WEST SUSSEX COUNTY COUNCIL CONSULTATION

TO:	Arun District Council FAO: Simon Davis
FROM:	WSCC – Highways Authority
DATE:	21 st April 2026
LOCATION:	Land North of Summer Lane Pagham
SUBJECT:	P/31/26/OUT Outline application with some matters reserved, except access, for up to 130 No residential dwellings including means of access into the site (not internal roads). This application is a Departure from the Development and affects a Public Right of Way.
DATE OF SITE VISIT:	10 th April 2026
RECOMMENDATION:	No Objection

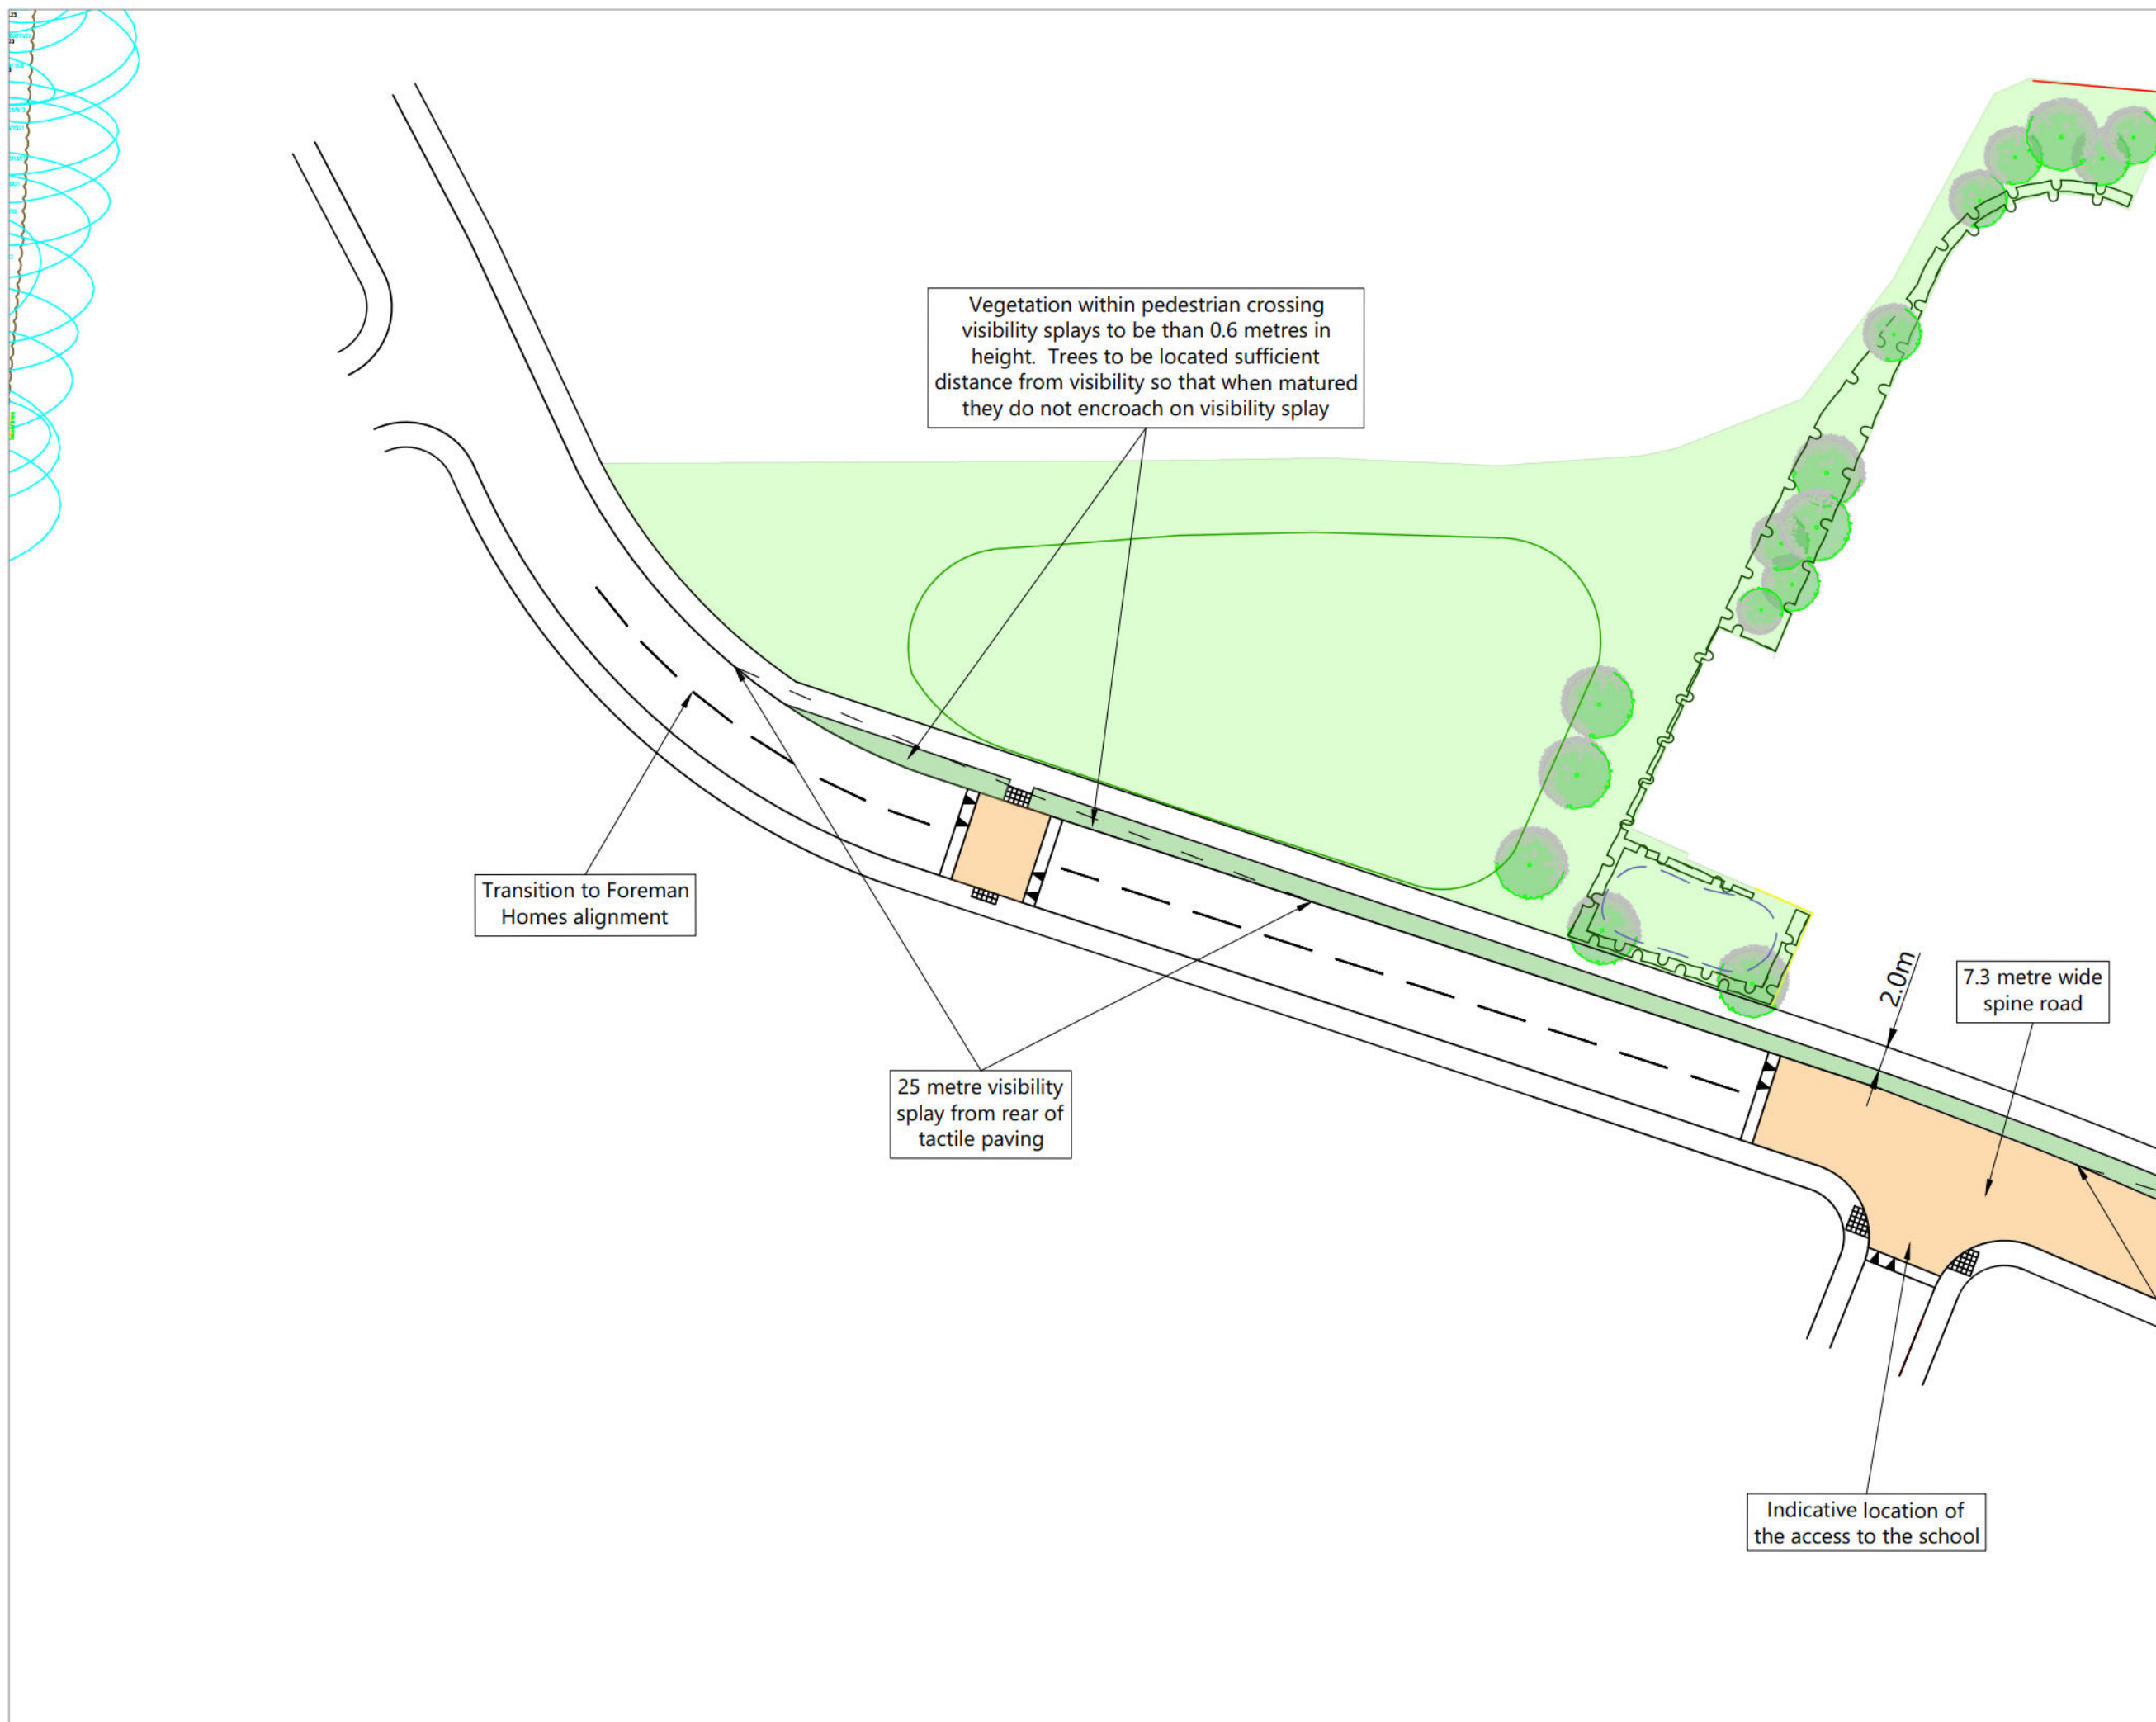
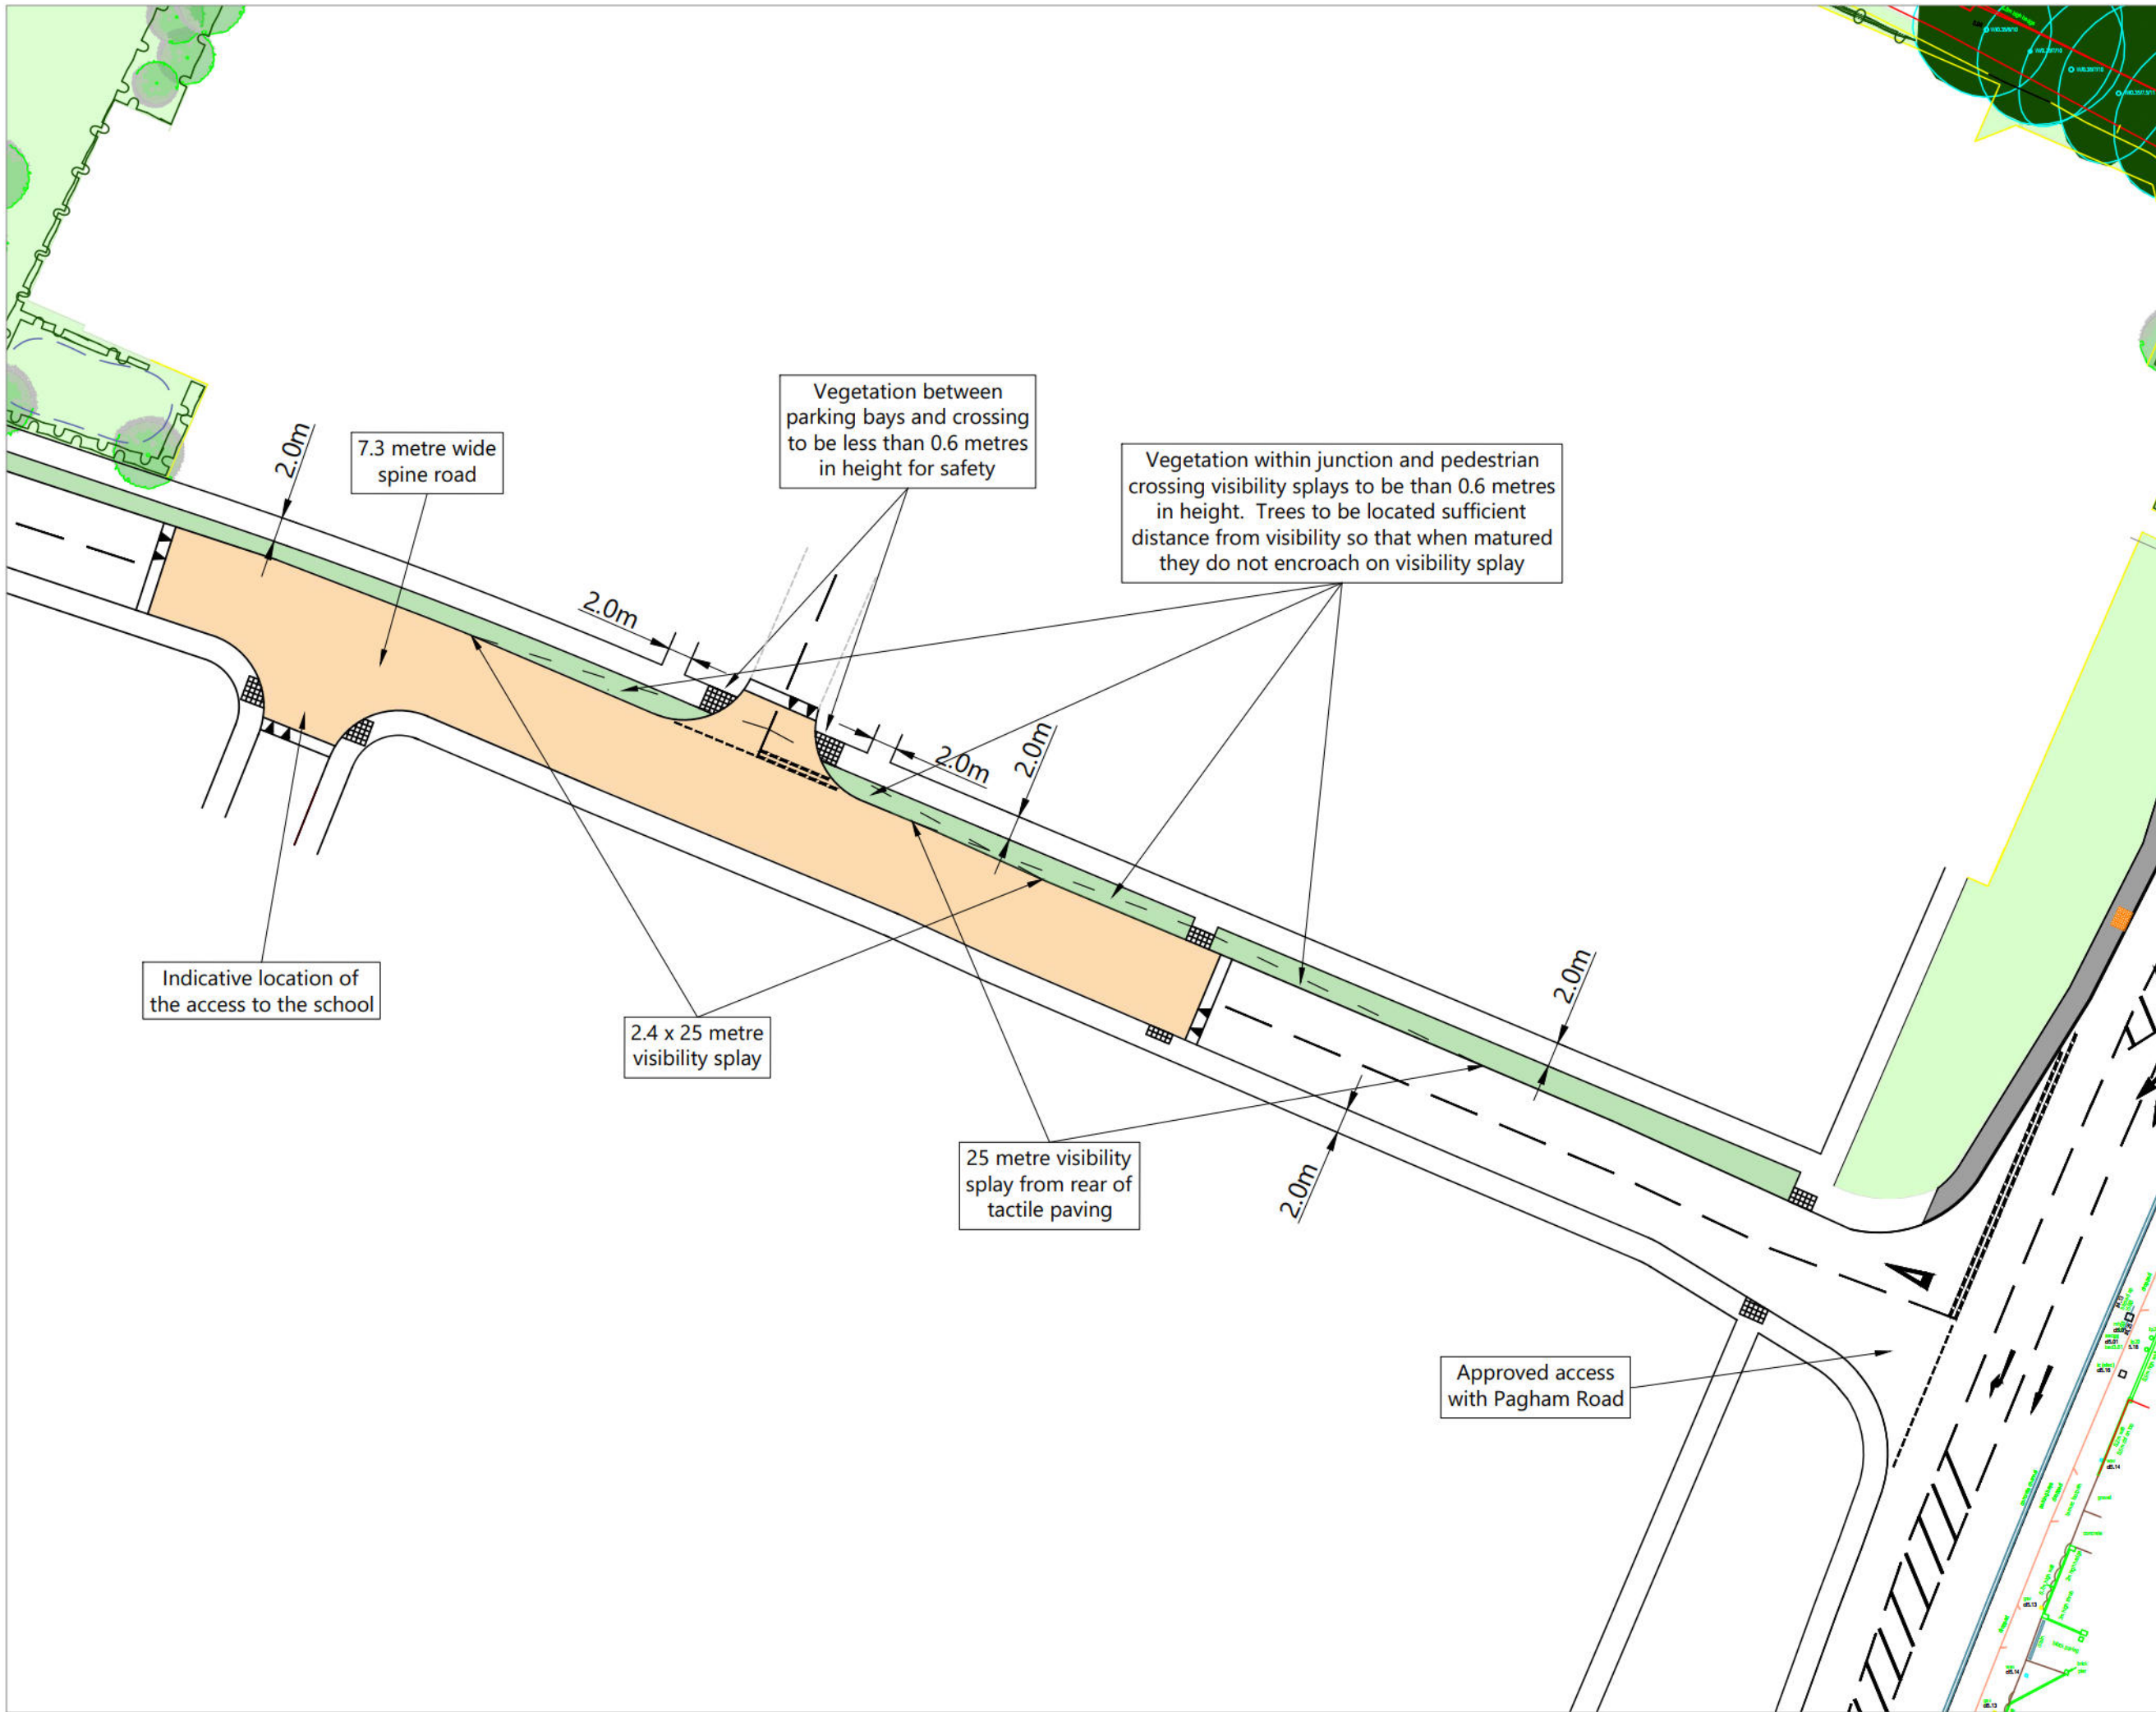
The proposals will provide one vehicular access through approved scheme (P/15/24/OUT) and the main spine road of Pagham South (P/140/16/OUT), via the approved northern vehicular access from Pagham Road, which is provided as a ghost island right turn lane arrangement. Drawing HTP/2152/07/G within the TA provides detail of the access arrangements. The access arrangements have been subject to a Technical Check through the S278 process with the LHA.
